Planning consultation: Erection of a 60.7m (to tip) single wind turbine
Location: Land north of Huntroyde Home Farm, Huntroyde West, Whins Lane, Simonstone.

We have a number of concerns about the submitted Landscape and Visual Impact Assessment (LVIA) that are set out below:

project title
figure title
figure reference
scale
date
N160: Huntroyde
Viewpoint 1: Trapp Lane, Whittle Hill
N160-GR-LVIA-013
1:25,000 @ A3
February 2013

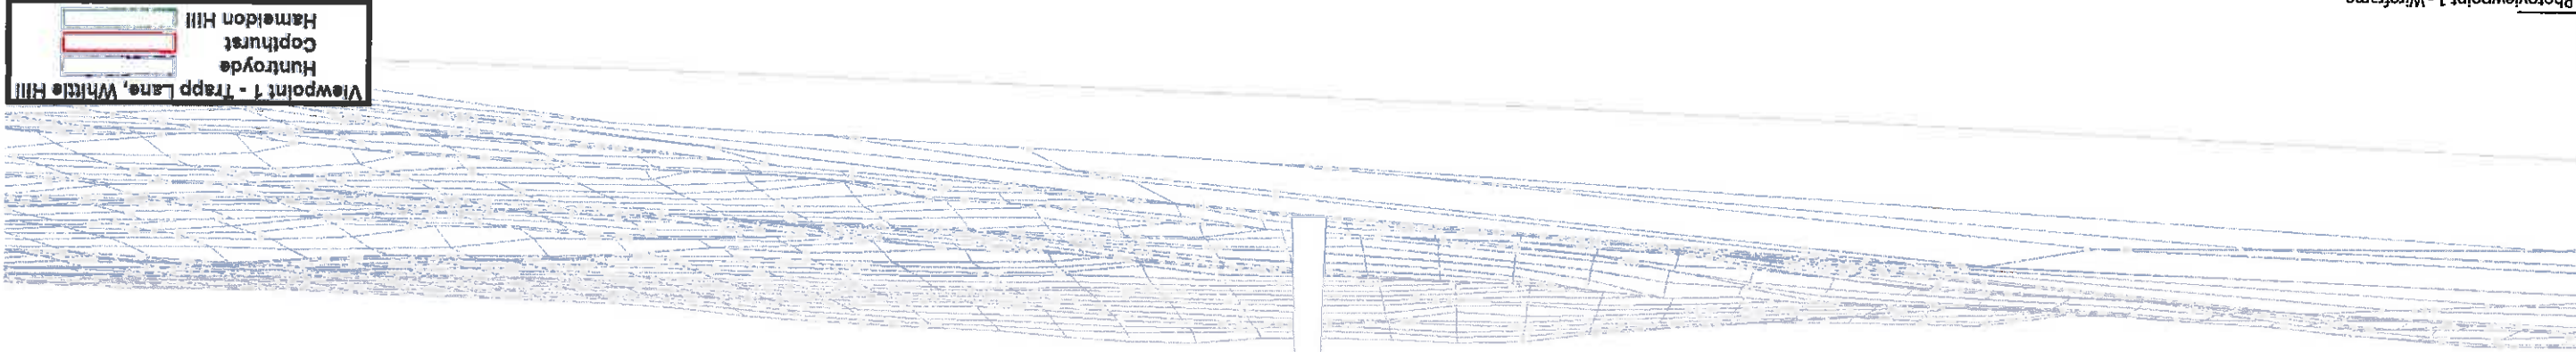
- Viewpoint 1 could have helpfully been angled slightly differently so that it was clear that the proposed Copthurst turbine (Pendle – 13/13/0135P) would also be viewed at this location, in addition to Viewpoint 3. However, we note that the 'panorama' photograph does pick this up.
- The viewpoint location map and the ZTV maps do not show the AONB boundary; we believe its inclusion would help to better understand the significance of the information illustrated.

project title	N160: Huntroyde
figure title	Viewpoint 2: Nick of Pendle,
figure reference	Clitheroe Road
scale	N160-GR-LVIA-015
date	February 2013

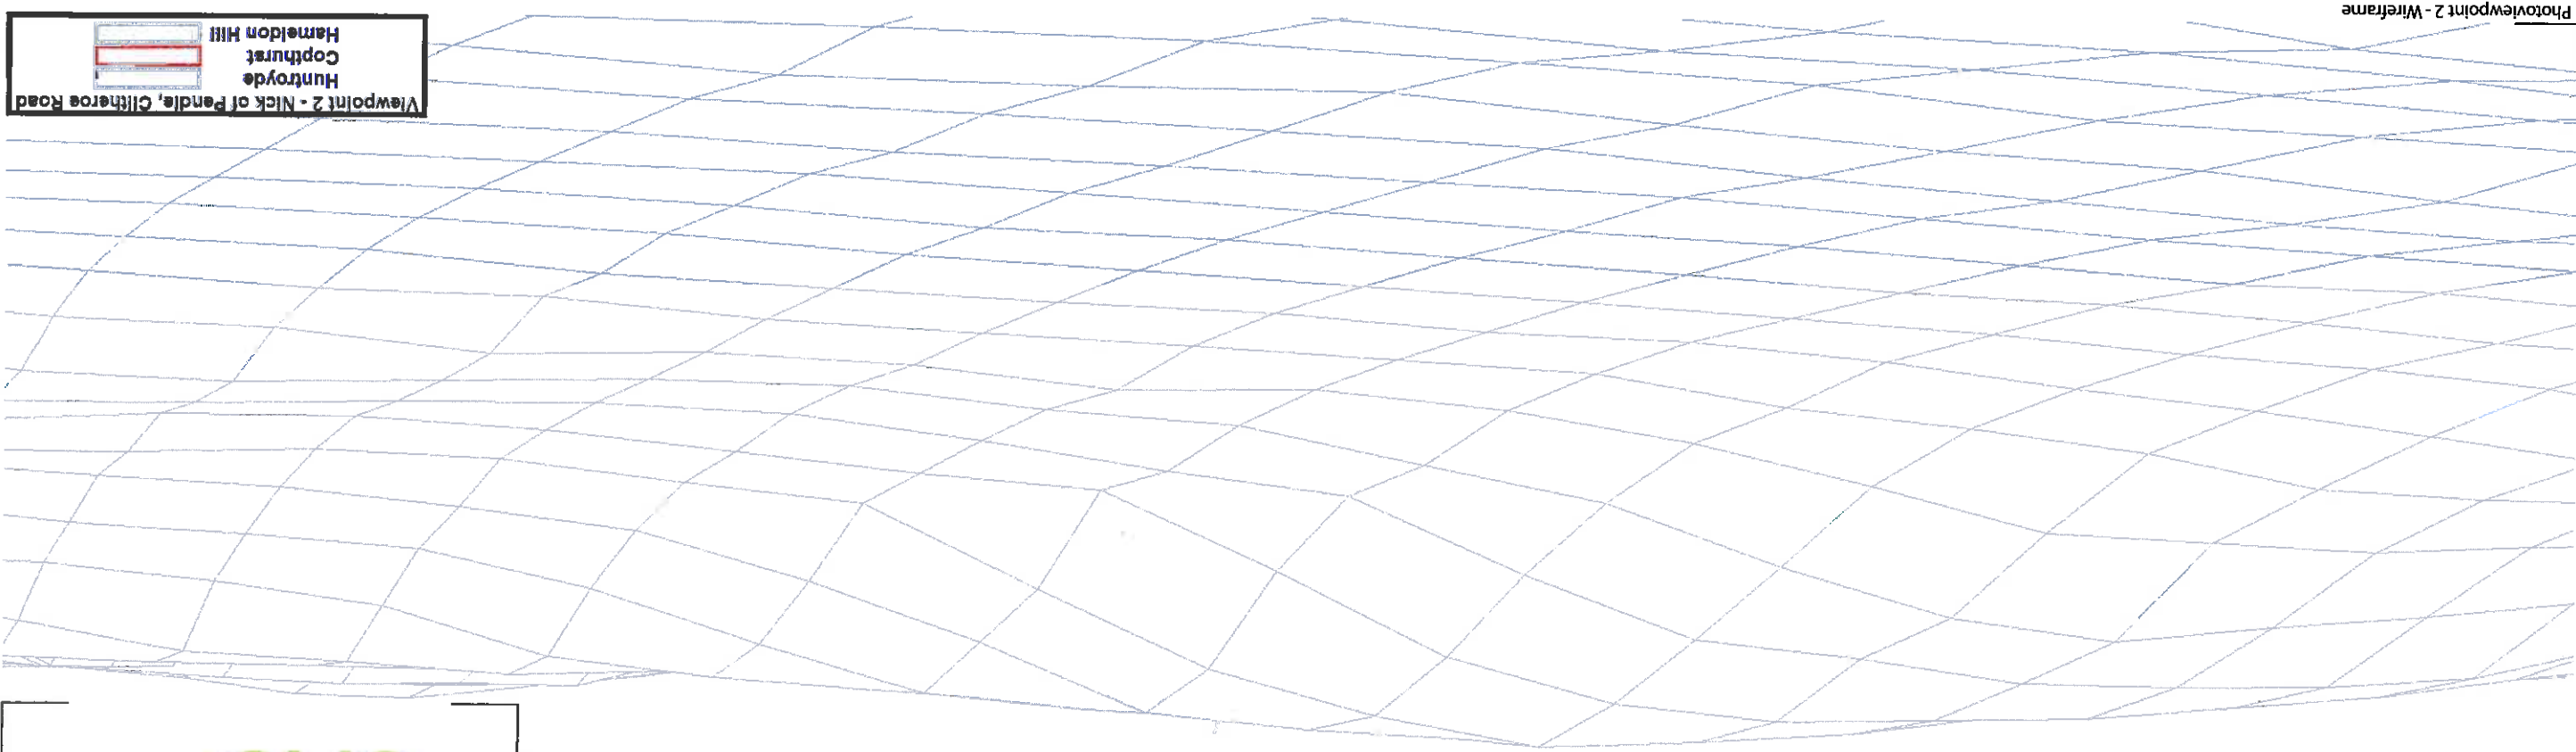
Viewpoint 2 is the most northerly location but appears to sit outside the areas of potential visibility; consequently the photomontage does not show the hub or blades of the turbine at all. What was the reasoning for using this VP when more appropriate locations appear to have been overlooked? **How much more of the turbine would be seen from viewpoints further upslope?**

Viewpoint 3 - Stump Hall, Stumphall Road
Huntroyde
Copthurst
Hameldon Hill

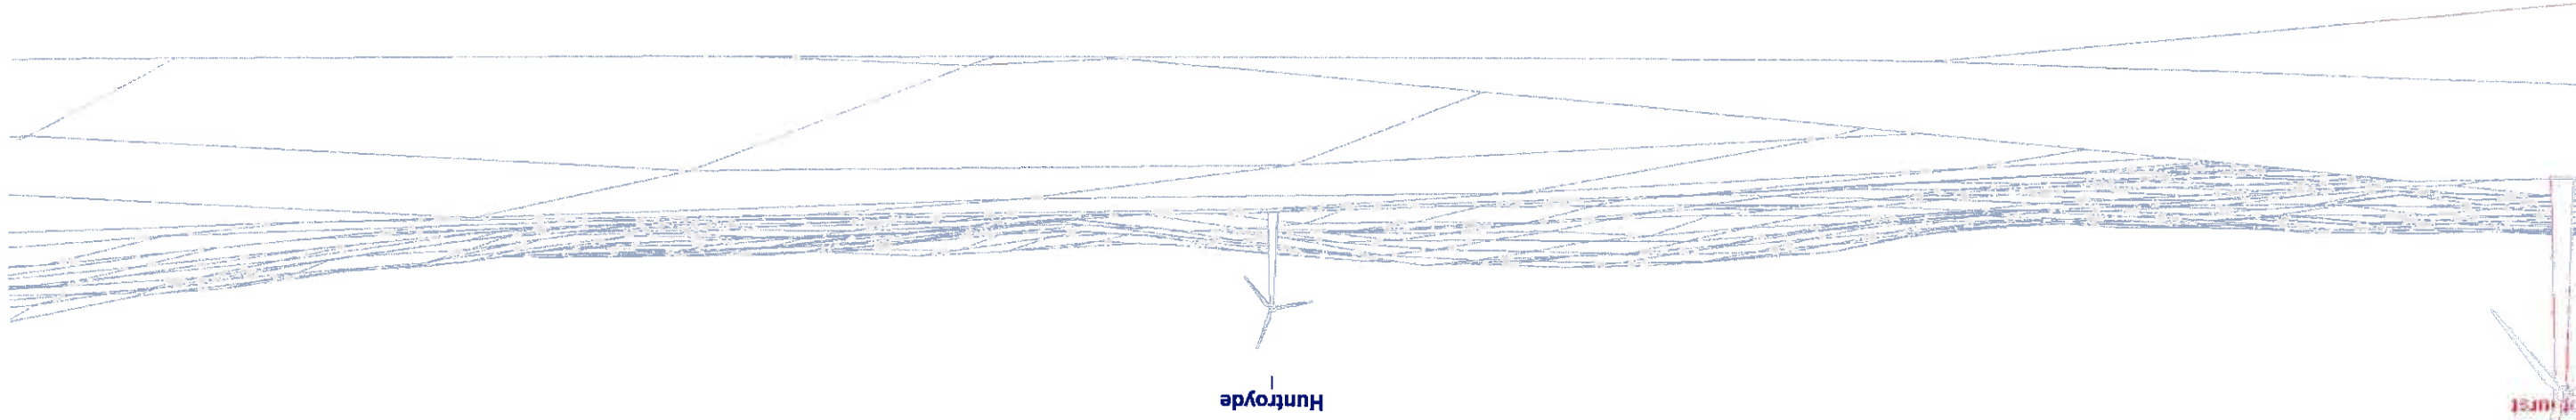
- Please note that pages 29 and 30 of Volume 1 of the LVIA are missing from the website. These pages will describe the assessment and overall conclusion of significance for Viewpoint 1.
- We disagree with the assessment that the magnitude of change at VP3 is low and consider it to be 'medium' – 'some change in the view that is clearly visible in the view and forms an important but not defining element in the view' (Table A-5).

Consequently the impact significance of the proposal at this location is 'moderate' (Table A-6) for footpath and minor road users, which may be regarded as a significant effect in terms of the Environmental Impact Assessment Regulations 2011³.

project title	N160: Huntroyde
figure title	Viewpoint 5: Padiham, A6068 Barrowford Road
figure reference	N160-GR-LVIA-021
scale	1:25,000 @ A3
date	February 2013

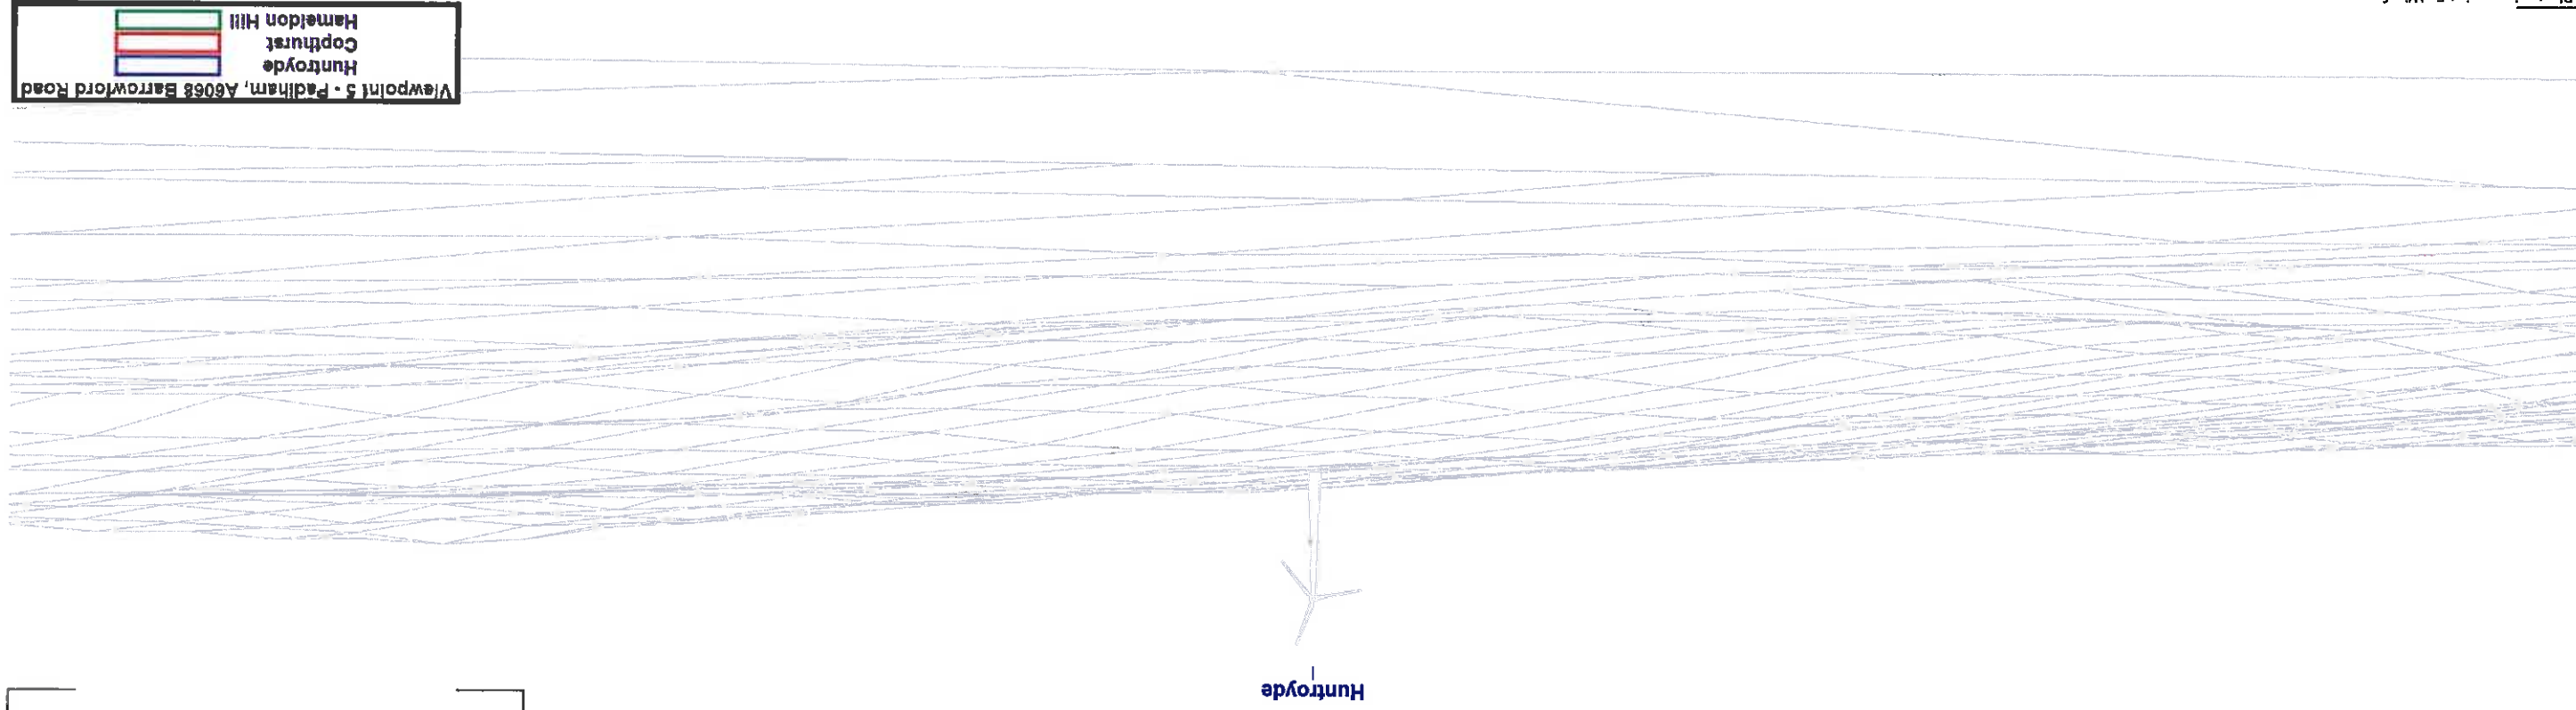
- We note that the LVIA concludes 'moderate' significance for visual impact on footpath users at Viewpoint 5, and also cumulatively with the proposed Copthurst turbine, with an overall determination of 'not significant' in terms of the EIA Regulations.

The location of Viewpoint 5 has also been used in the Copthurst turbine's LVIA and we considered, in our response to Pendle Council, that the magnitude of change was high thus making a 'substantial' level of impact significance. We noted that this would be regarded as a significant effect in terms of the Environmental Impact Assessment Regulations 2011³ in our response.

Consequently, we are concerned that the cumulative impact significance of both turbines might be underestimated at this location.
